Town & Country Planning Act 1990 (as amended)
Town & country Planning (Development Management Procedure) (England) Order 2015
Application for Planning Permission for Works or Extension to a Dwelling

Development Single storey side link extension.

Location 34 Churcill Avenue Aldwick

north

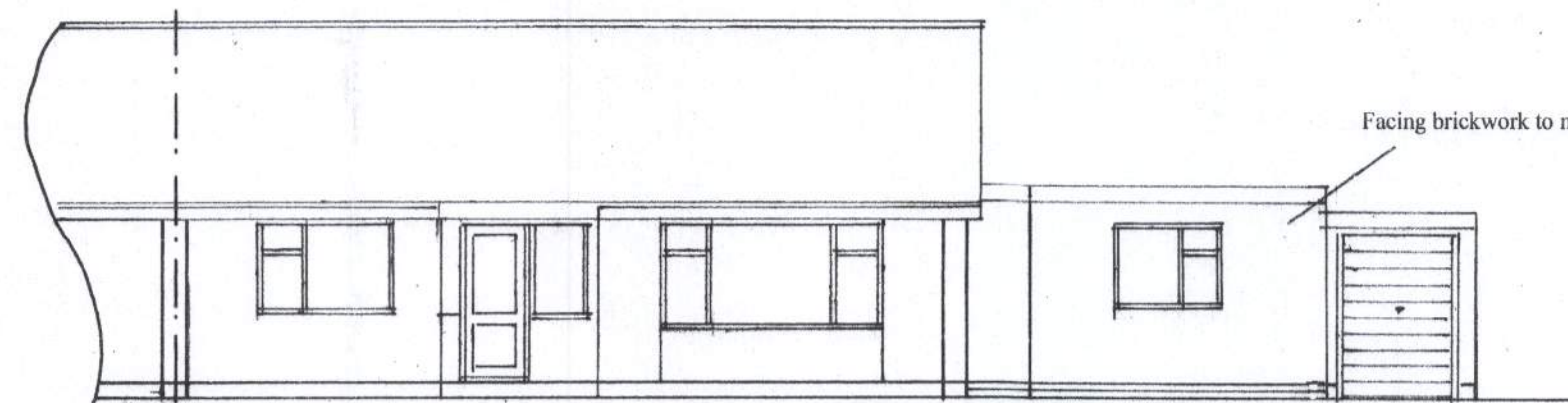
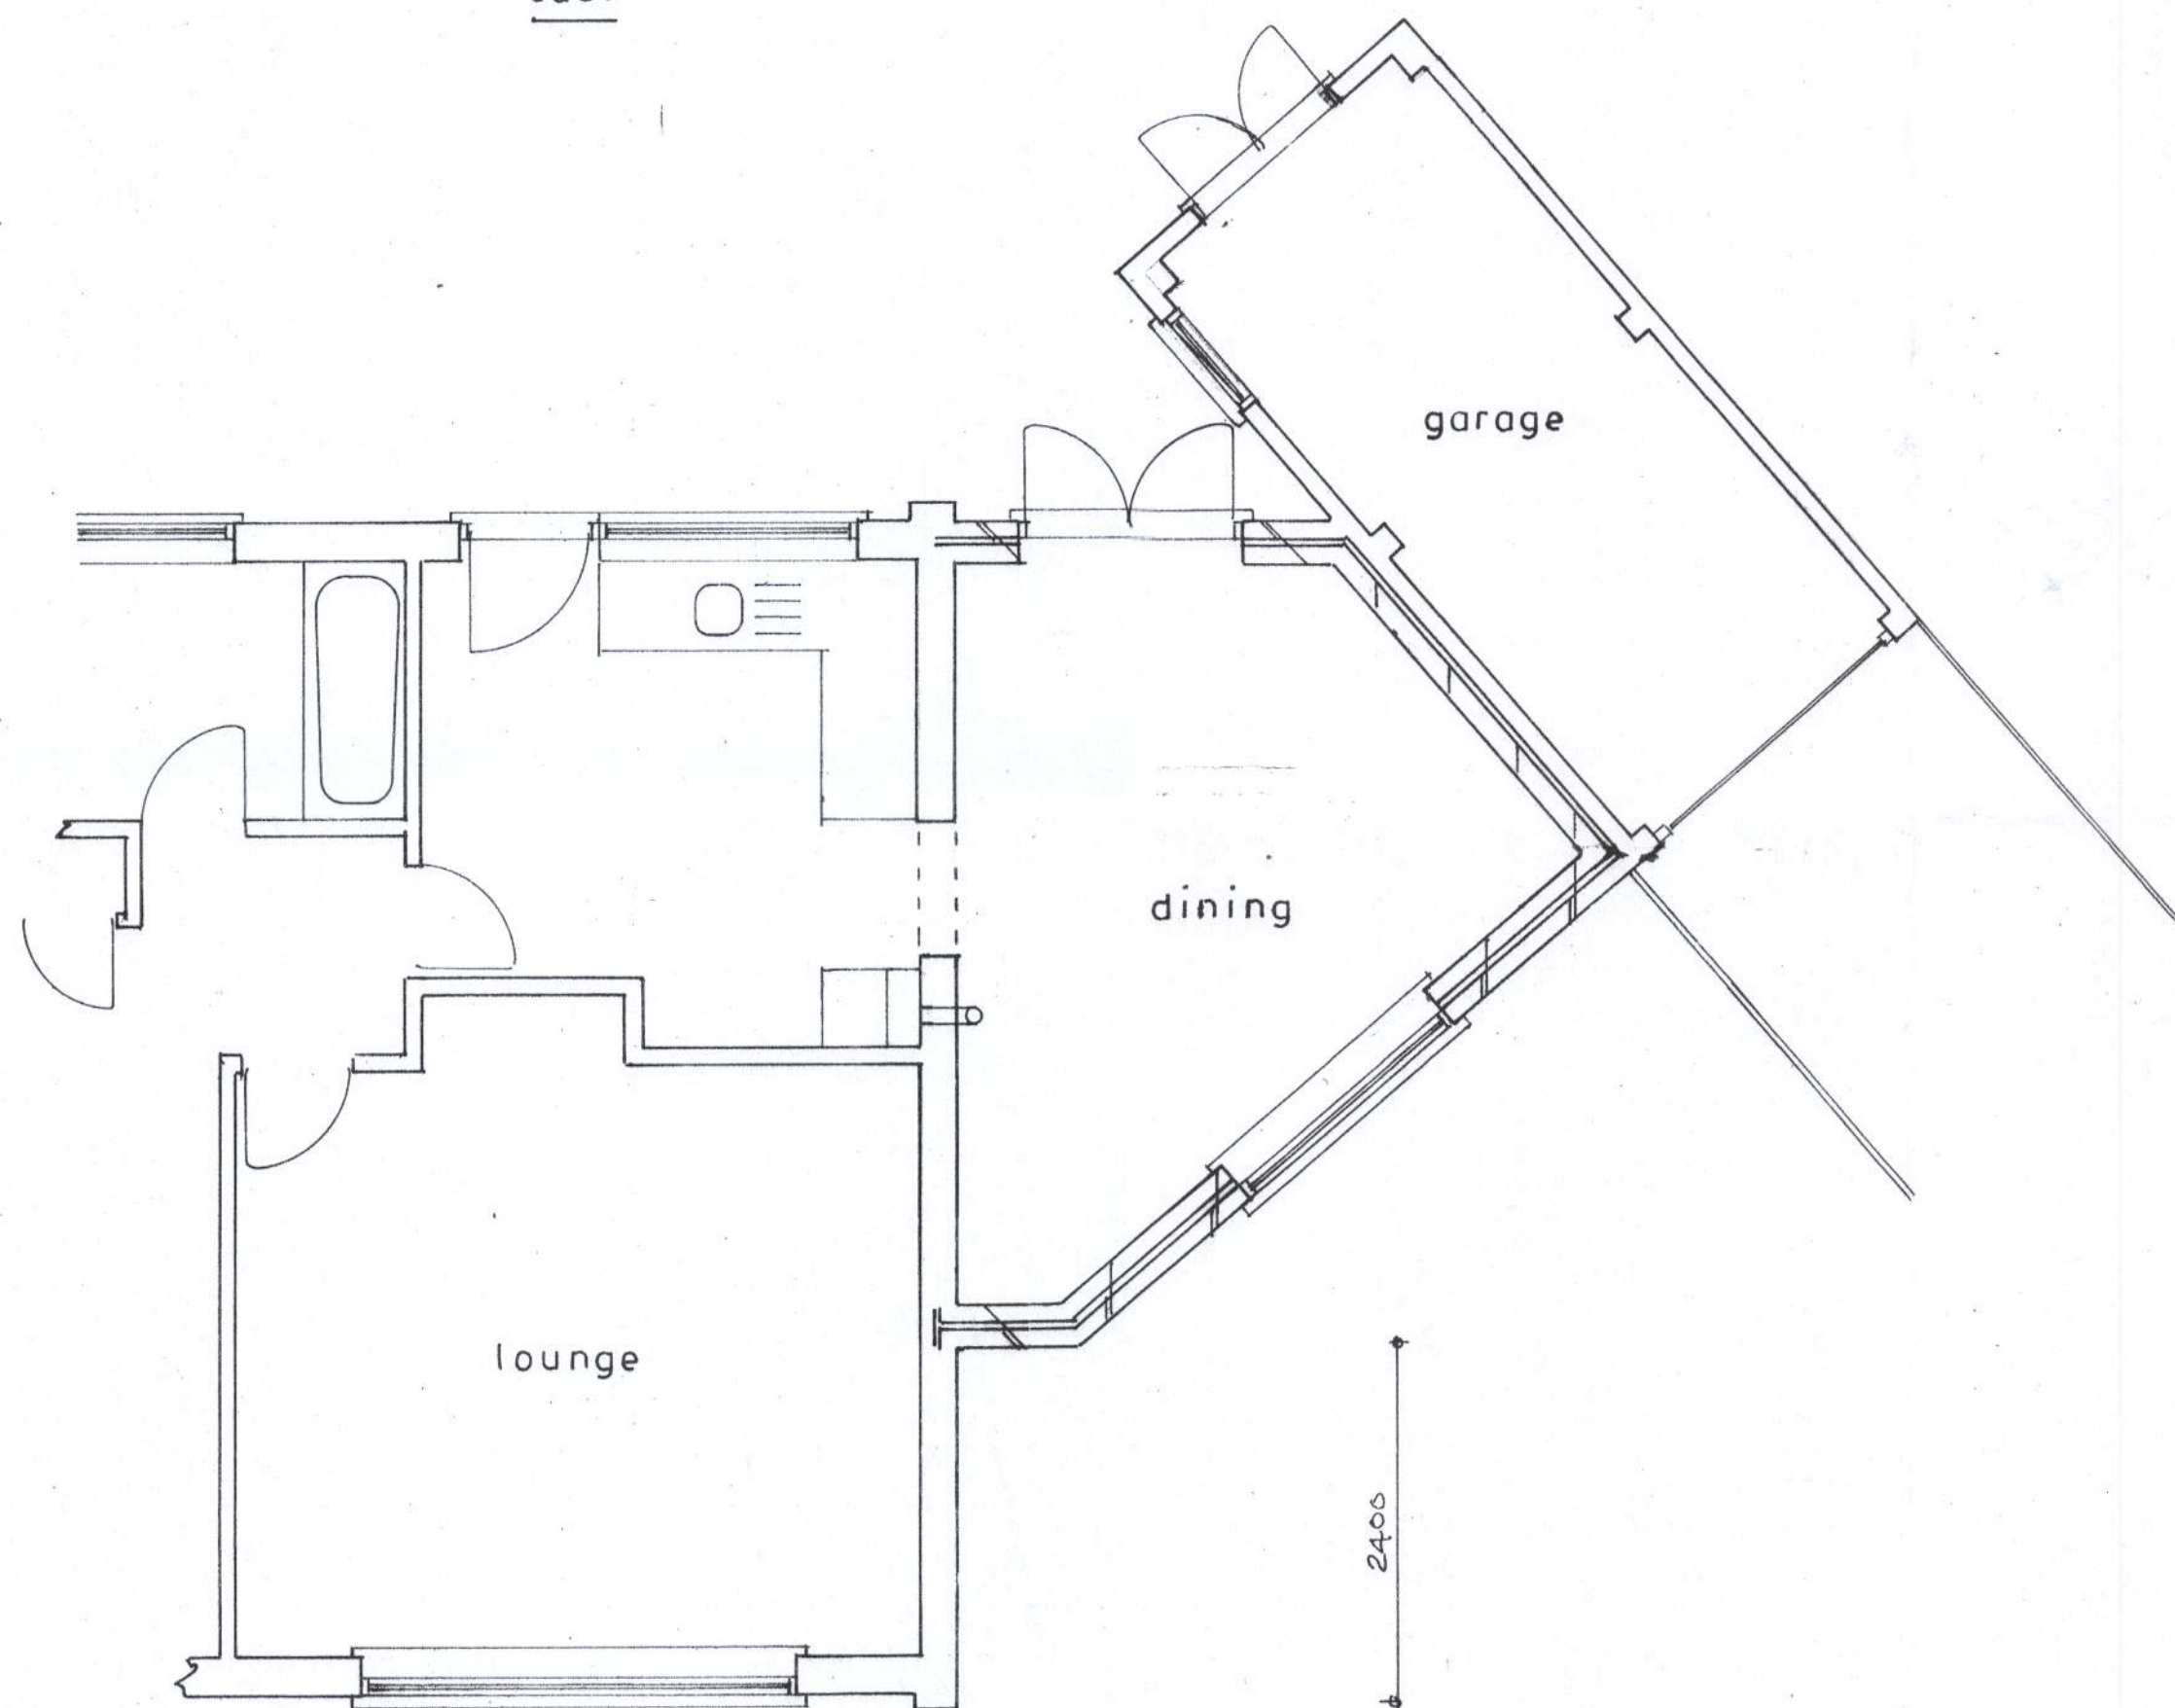
The proposed north elevation and floor plan do not accord. Please amend accordingly

east

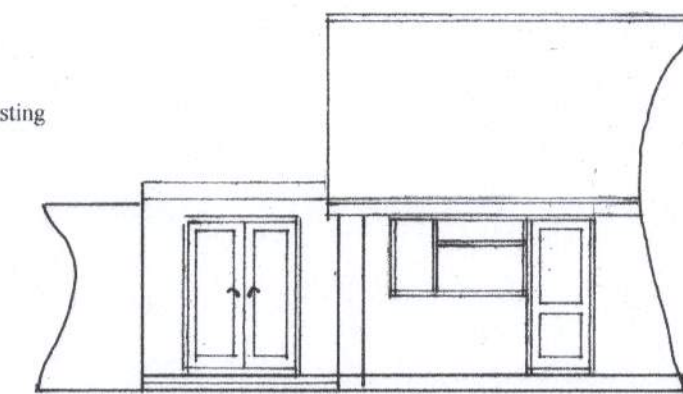
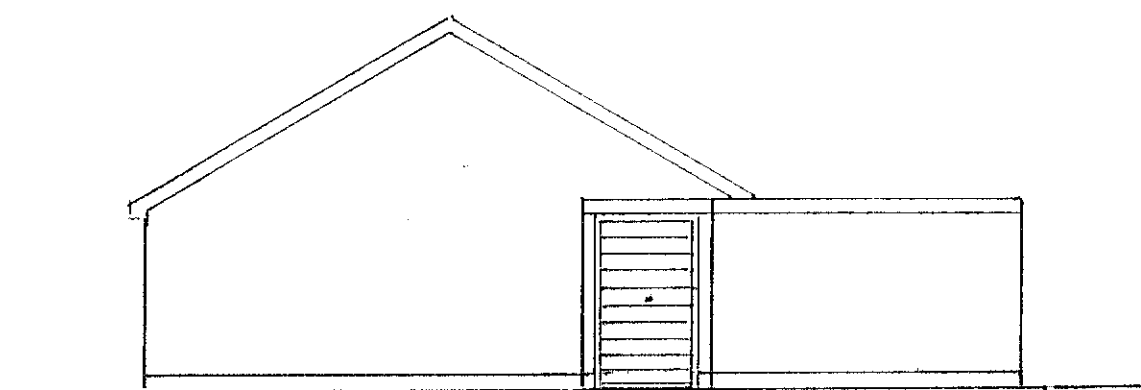
The existing and proposed east elevations have been mislabelled. Please amend accordingly.
